From: Amanda Scholes on behalf of Planning.Responses
Sent: 16 October 2019 08:25
To: Planning Scanning
Subject: FW: BR/120/19/PL, BR/121/19/L, The Bandstand

RAILING REPLACEMENT / REPAIR  
DETAILS - SHEET 1 OF 2

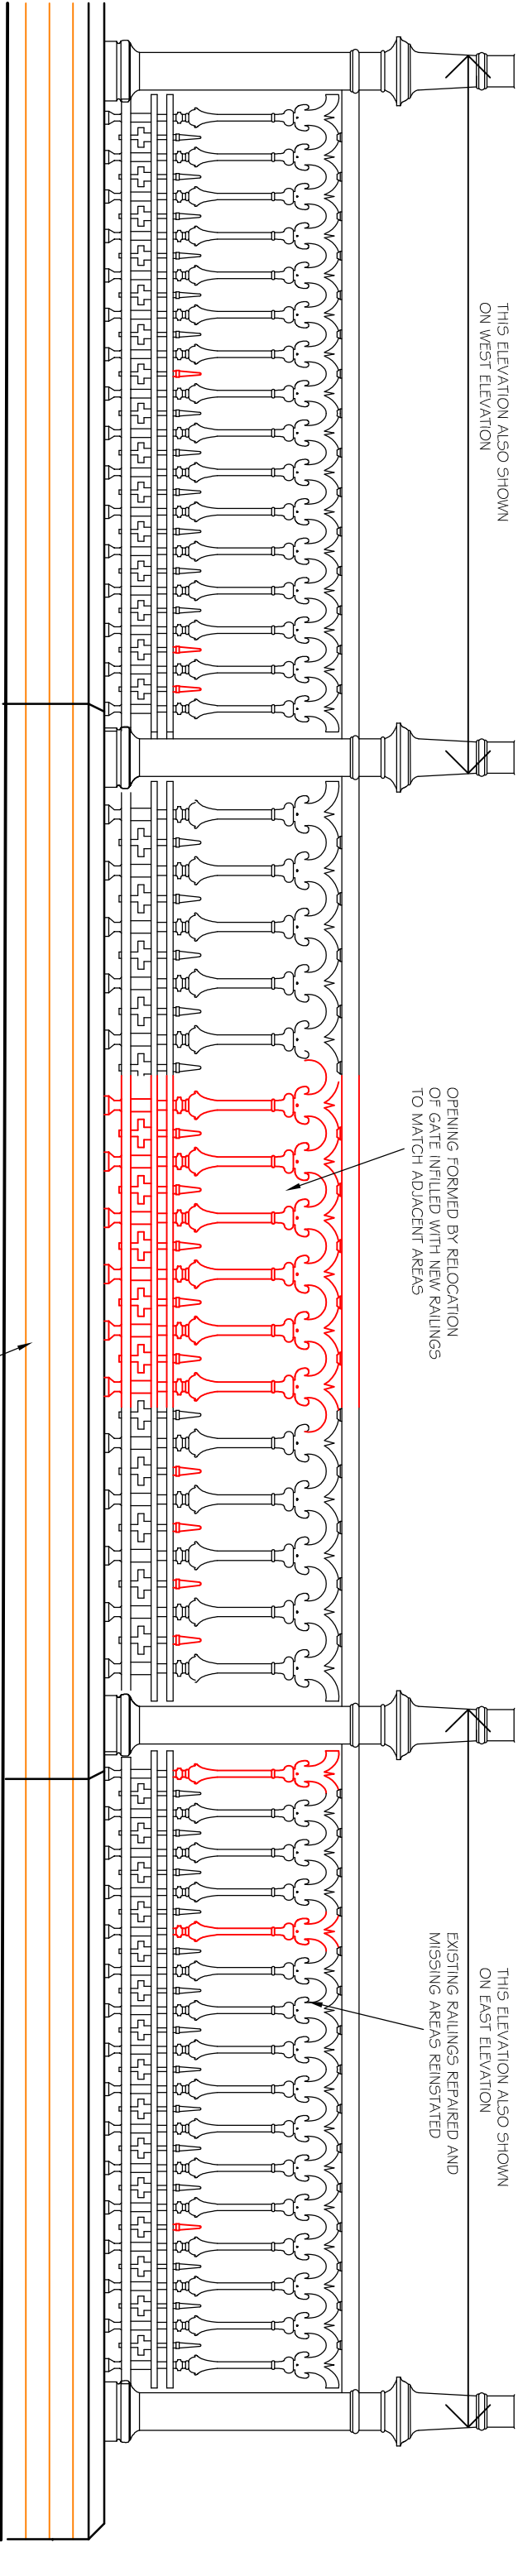
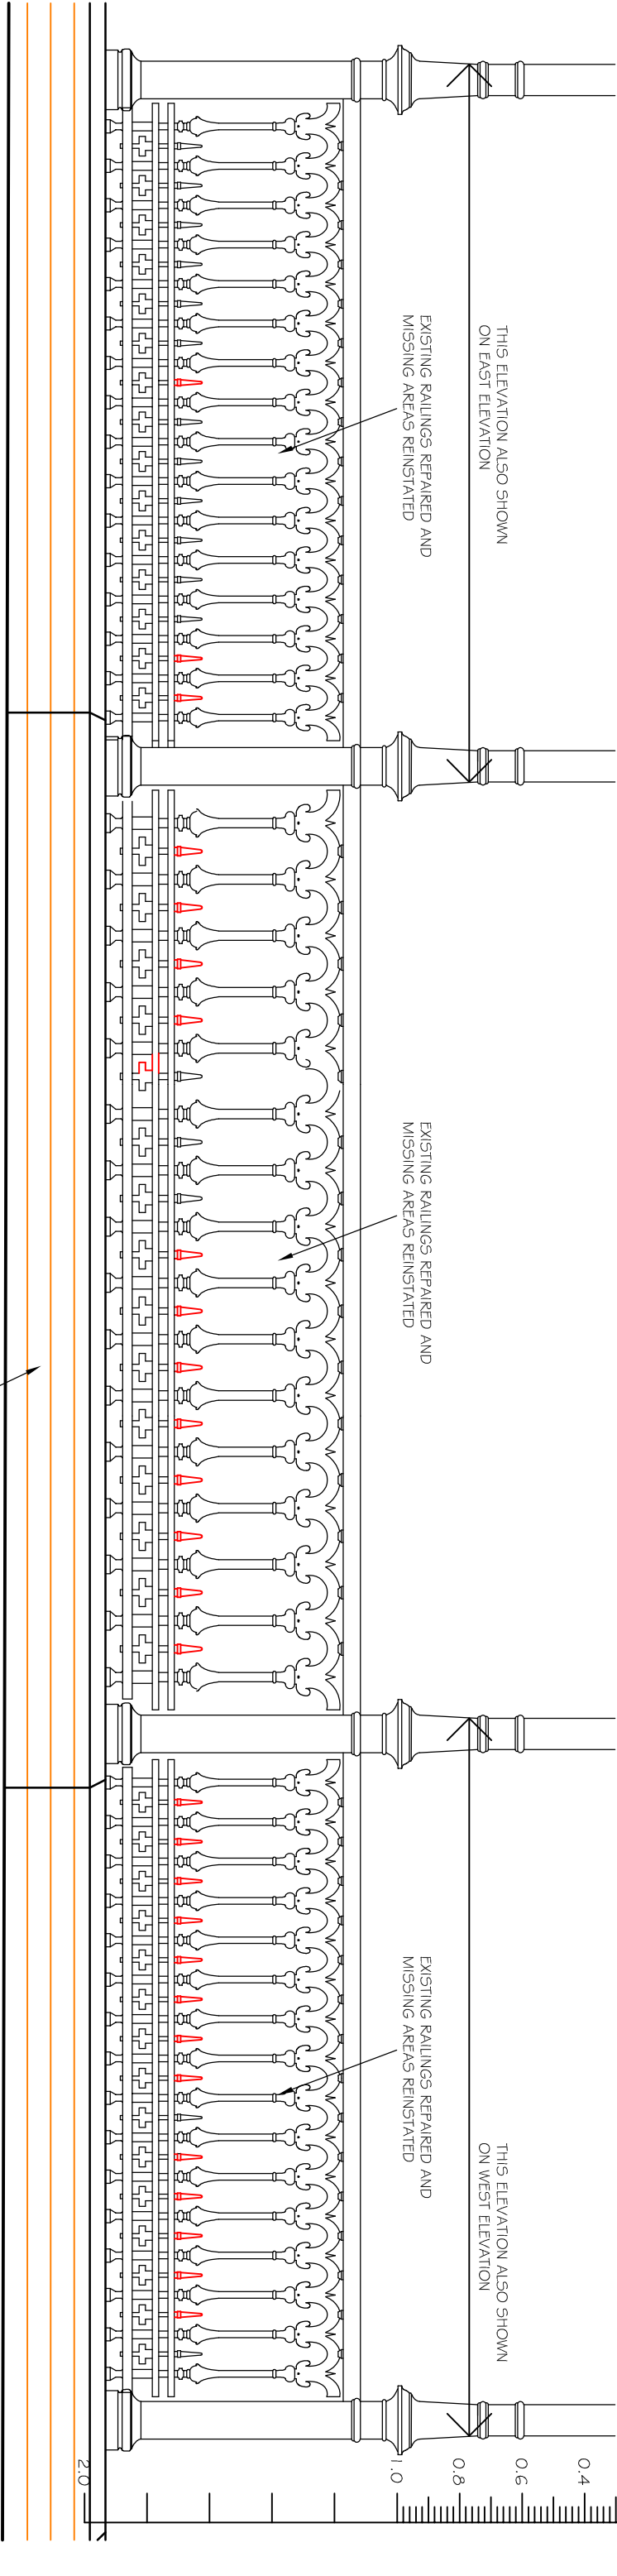
However, there are some issues which require clarification. It is not clear from reviewing the information why the location of the gate is to change.

- **Relocation of access gate.** The Bandstand has previously been disassembled and re-assembled and is not in its original location. There is no particular historic or architectural significance related to the current positioning of the access gate except that it faces directly onto the seafront. The balustrading and handrail (and associated access gate) are relatively interchangeable between the main structural support posts as the structure is a regular, symmetrical shape. The relocation of the gate will position it where there is currently an access step, which would seem an entirely logical location as this position would enable easy access and egress without disturbing the main thoroughfare along the promenade.
